The Examining Authority  
Planning Inspectorate  
National Infrastructure Planning  
Temple Quay House, 2 The Square  
Bristol  
BS1 6PN

**Order Granting Development Consent for Tween Bridge Solar Farm at Land either side of the M180, High Level Banks (the A18) and the Stainforth and Keadby Canal (EN010148)**

**Deadline 1: Written Representations**

Figure 1 : 16413_P13_Habitat Features_JS_RR

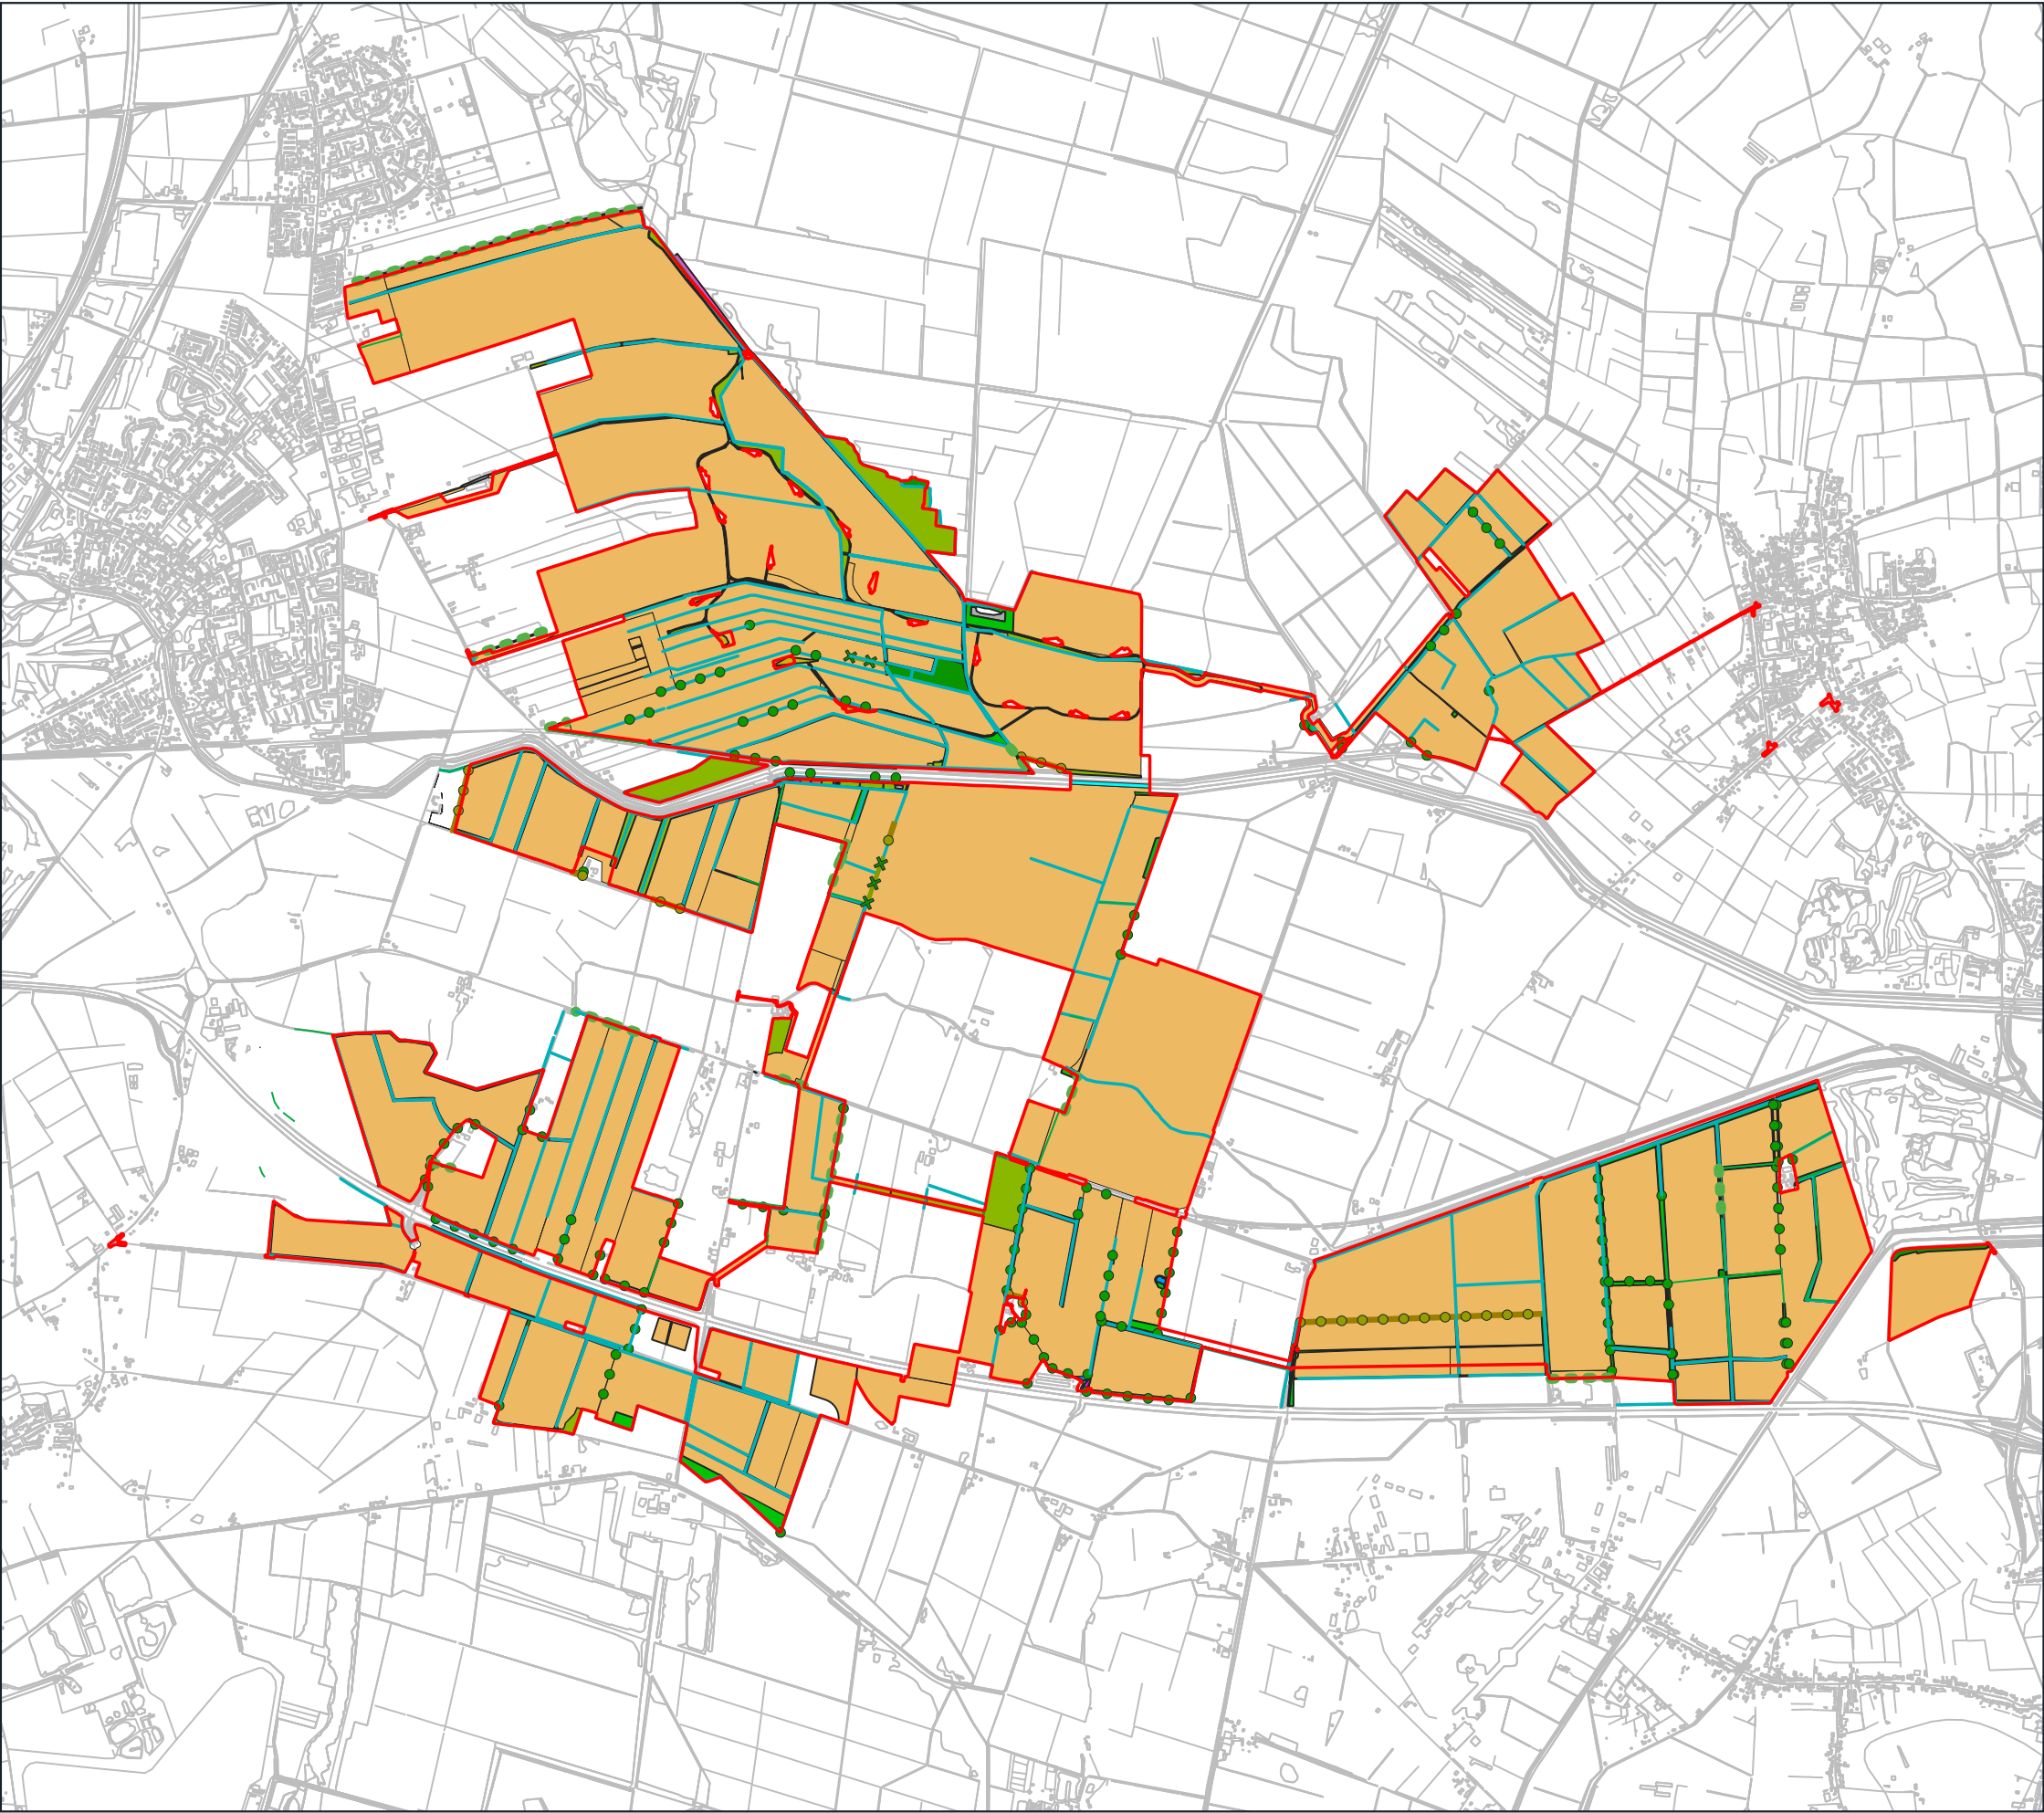
There appears to be a contradiction between the BNG Metric and the BNG Assessment [APP 082]. Paragraph 2.12 of the BNG Assessment states that all ditches are being retained and enhanced as part of the Scheme. However, in the Metric, only Ditches under Reference 3, those that are in Poor condition, are showing as being enhanced.

The DCO application outlines that 125 locations are presumed to require either the creation of a new culvert or the reinforcement/widening of an existing culvert/bridge structure [APP-039]. Whilst the Metric calculation shows that watercourses will meet the 10% BNG uplift, this does not take into account impacts to existing culverts or the creation of new culverts.

We advise that any new culverts should be recorded as lost, which will reduce the overall watercourse footprint, but this does not appear to have been the approach taken. We therefore consider it likely that additional enhancements will be required to mitigate these effects to ensure delivery of 10% net gain.
